**Development Facilitation Team (DFT) – Review Comments**

**DRB Project No: PR-2020-003484 Date: 06/28/2023 Agenda Item: #9 Zone Atlas Page: E-10**

**Application For: SD-2023-00048 – PRELIMINARY PLAT (DHO)**

DRB Project Number: 2020-003484 Hearing Date: **06-28-2023**  
 Project: Mojave Ridge Subdivision Agenda Item No: **9**

**MOJAVE SUBDIVISION**  
 GRADING AND DRAINAGE  
 GRADING PLAN

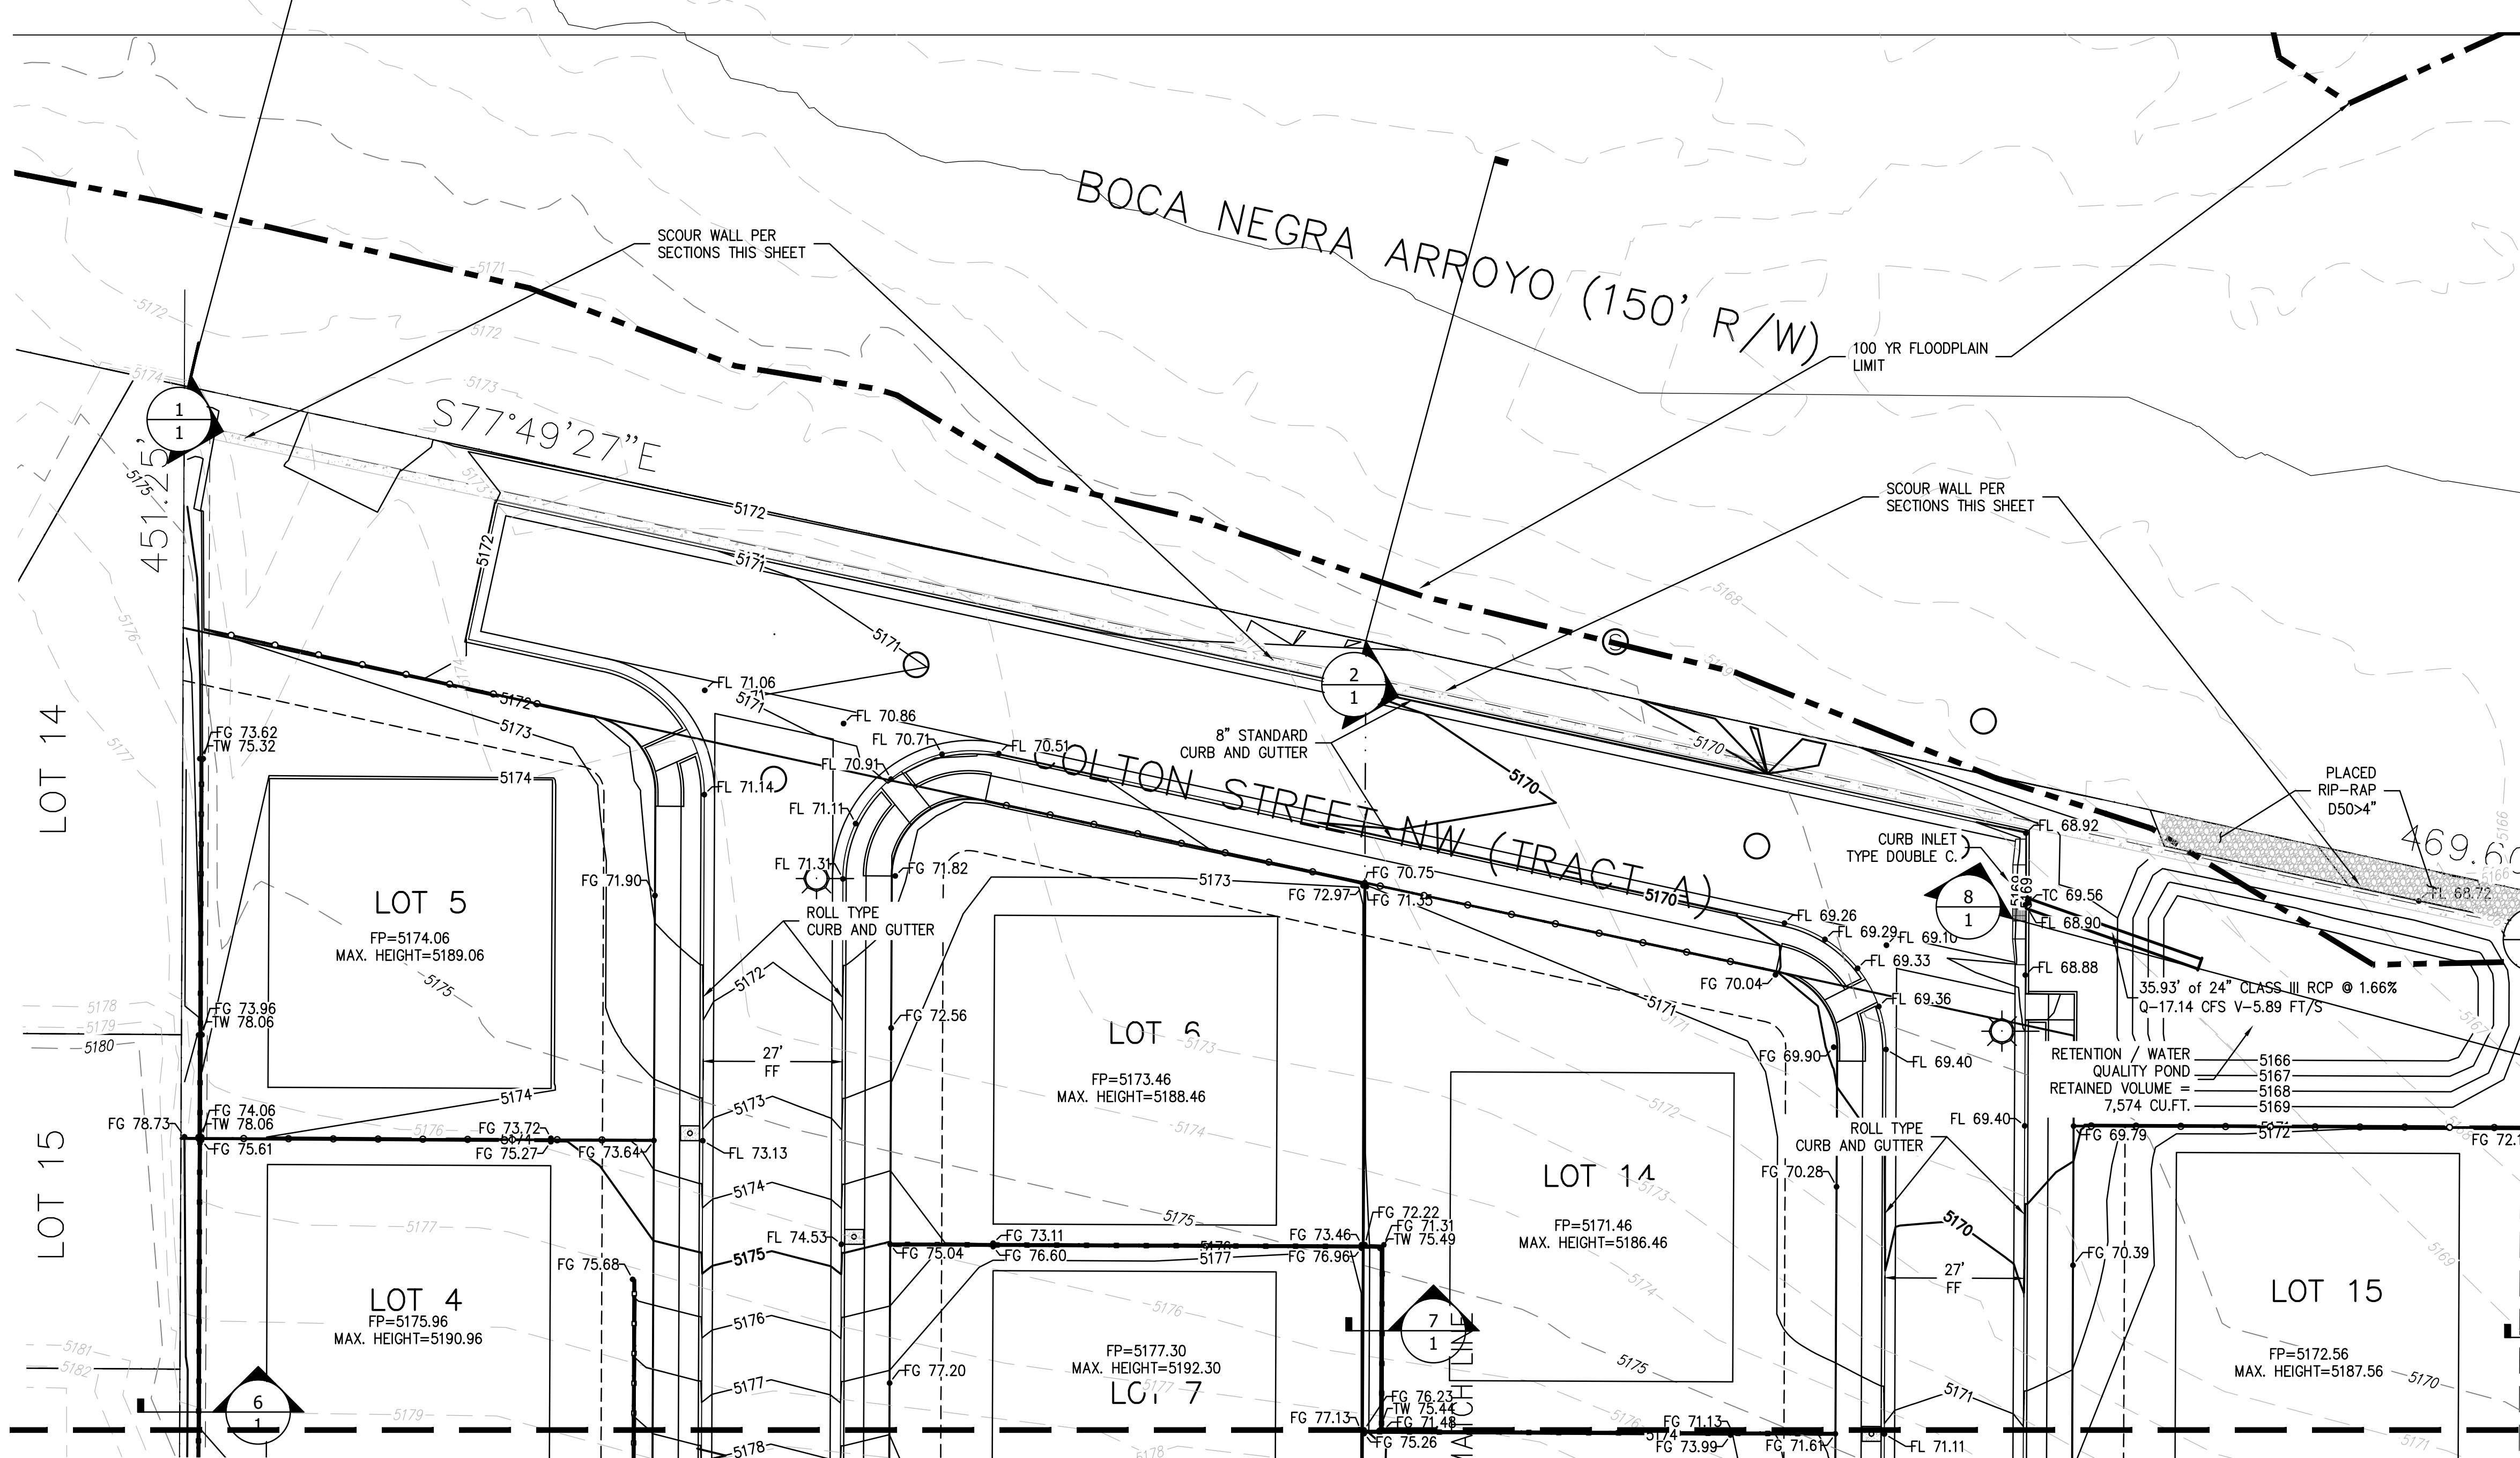
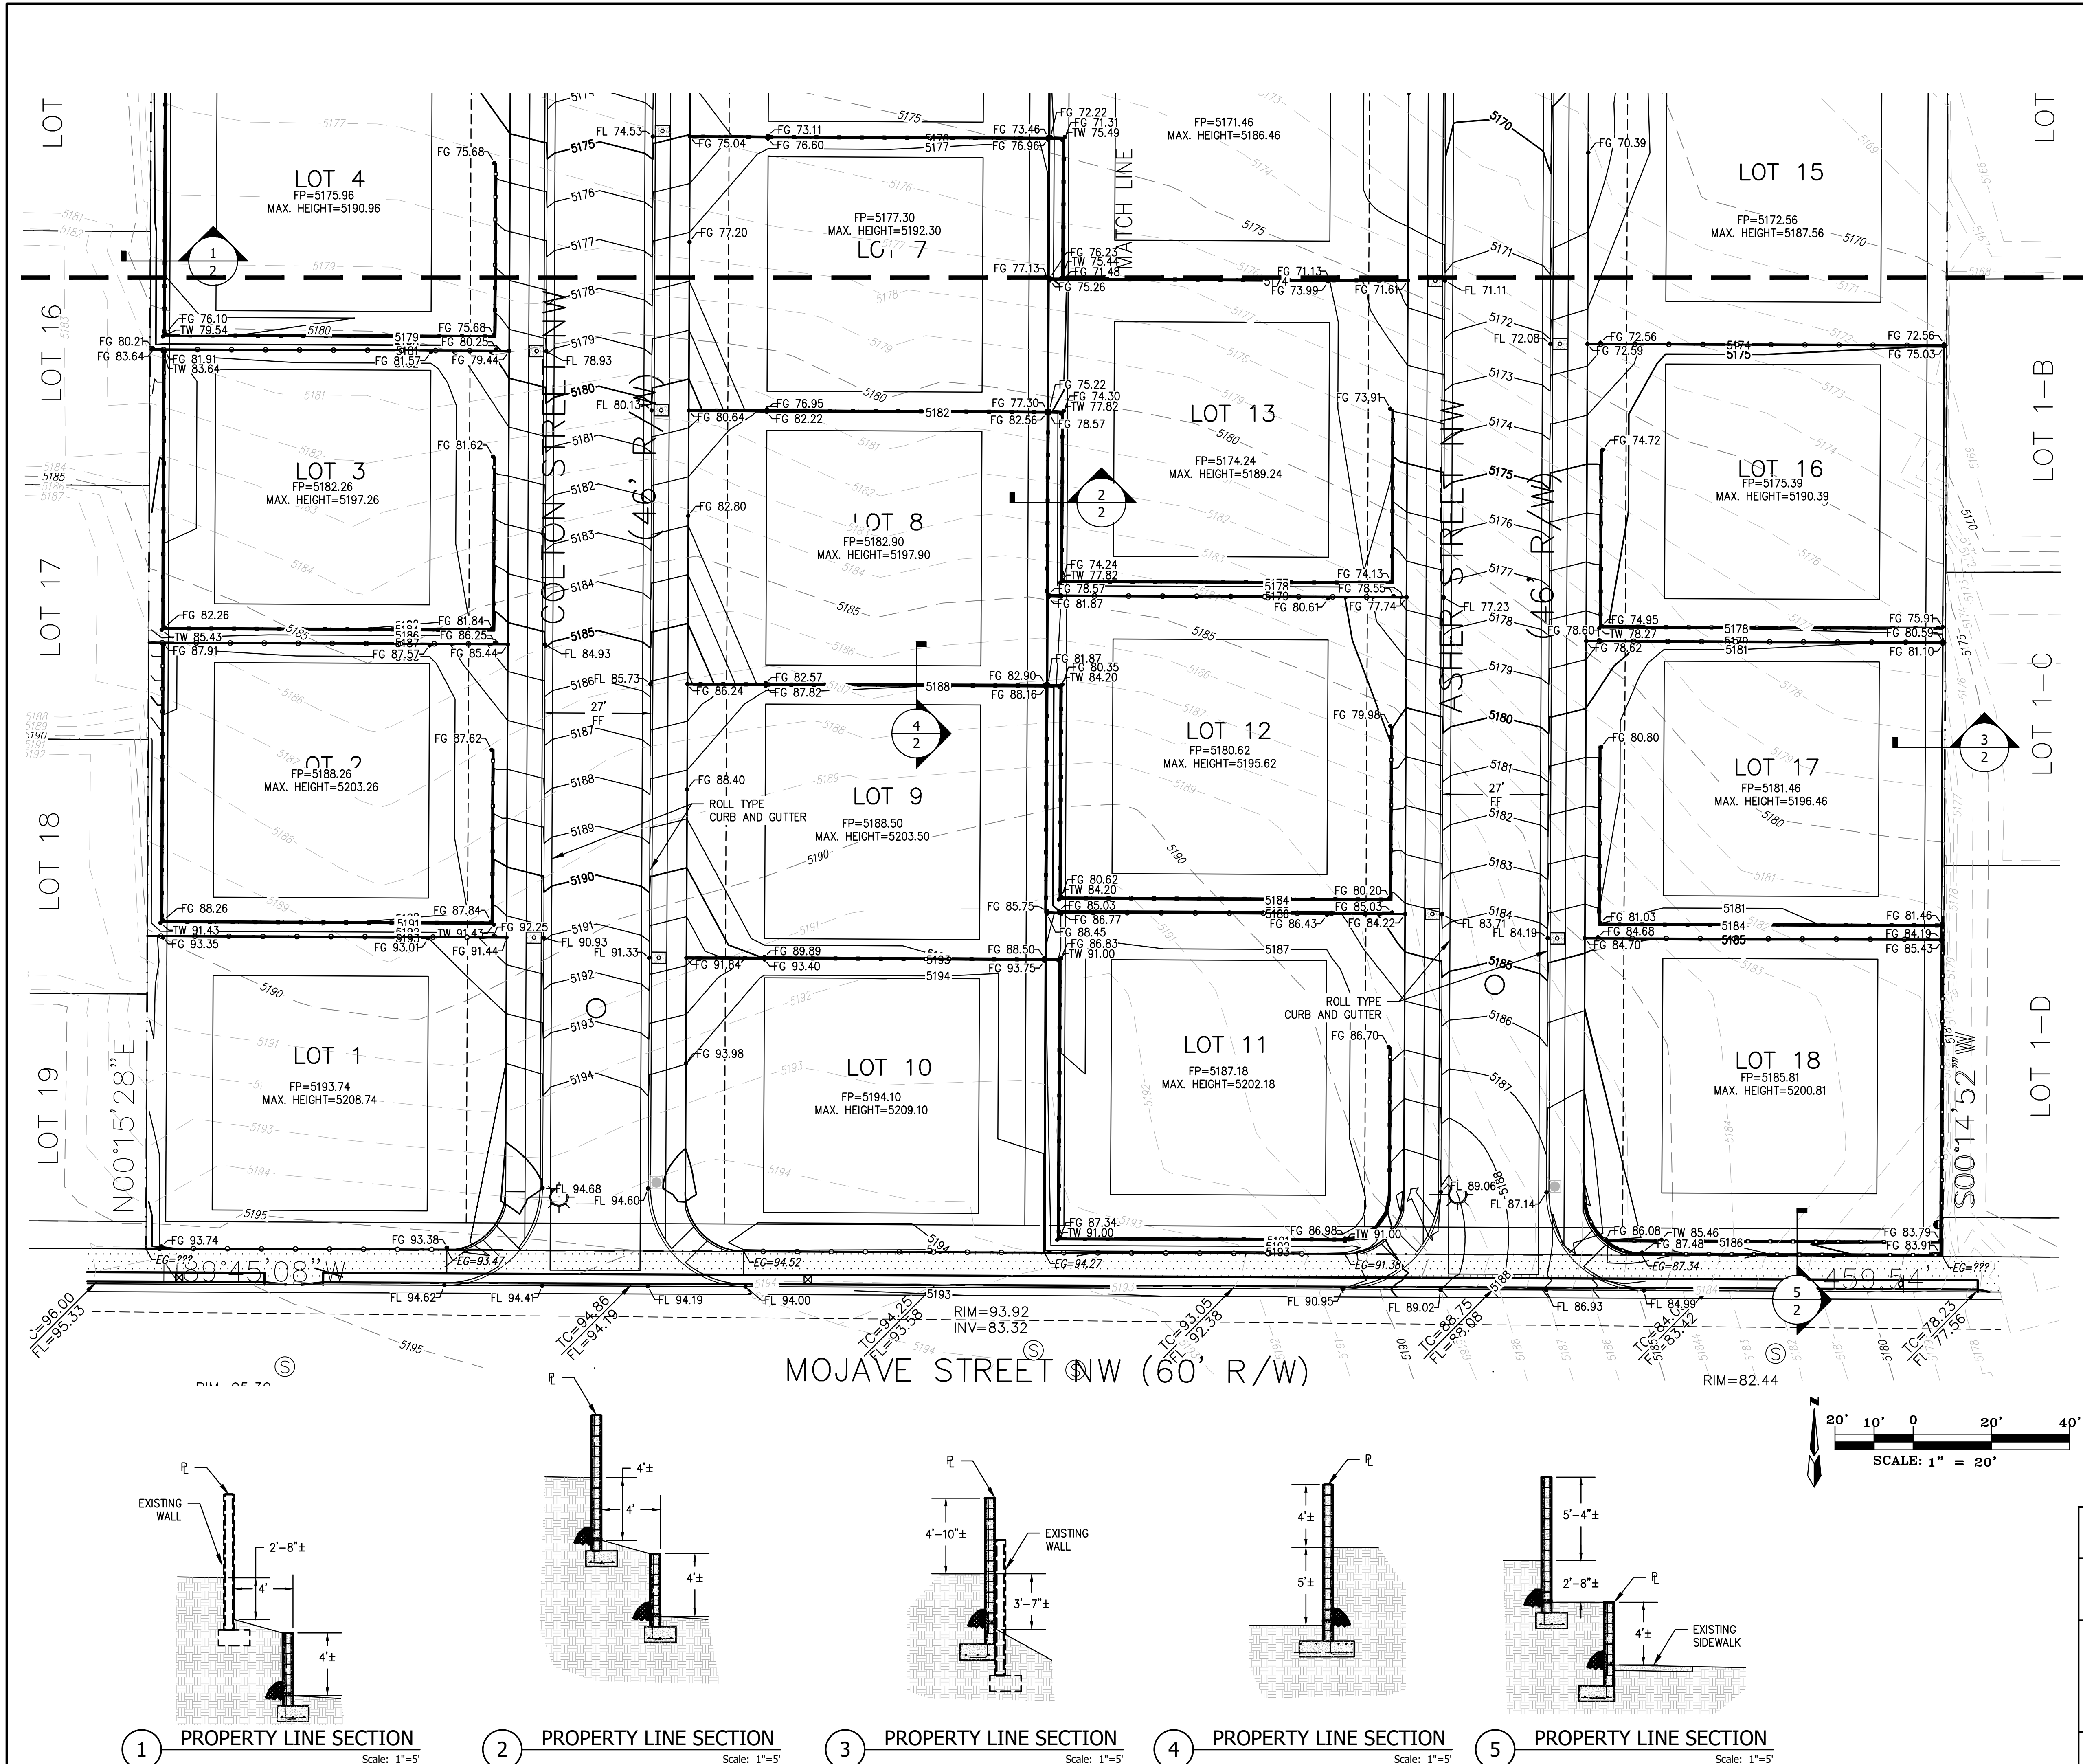
- **Updated 6.28.23:** Planning staff, Open Space Staff, NPS Staff, the agent and the applicant did a field visit on 6.15.23. It was clarified in the field visit that the connection to the sewer line could be a small disturbance if a 6-8 feet wide trench extending 6-8 feet into PNM. The only visible part would be a manhole and there are two similar manholes in the corridor. The other change reviewed was if the drainage pond were to overflow into the PNM land, then it would be a sheet of water rather than an outflow. This seemed to be more acceptable to NPS and City Open Space.
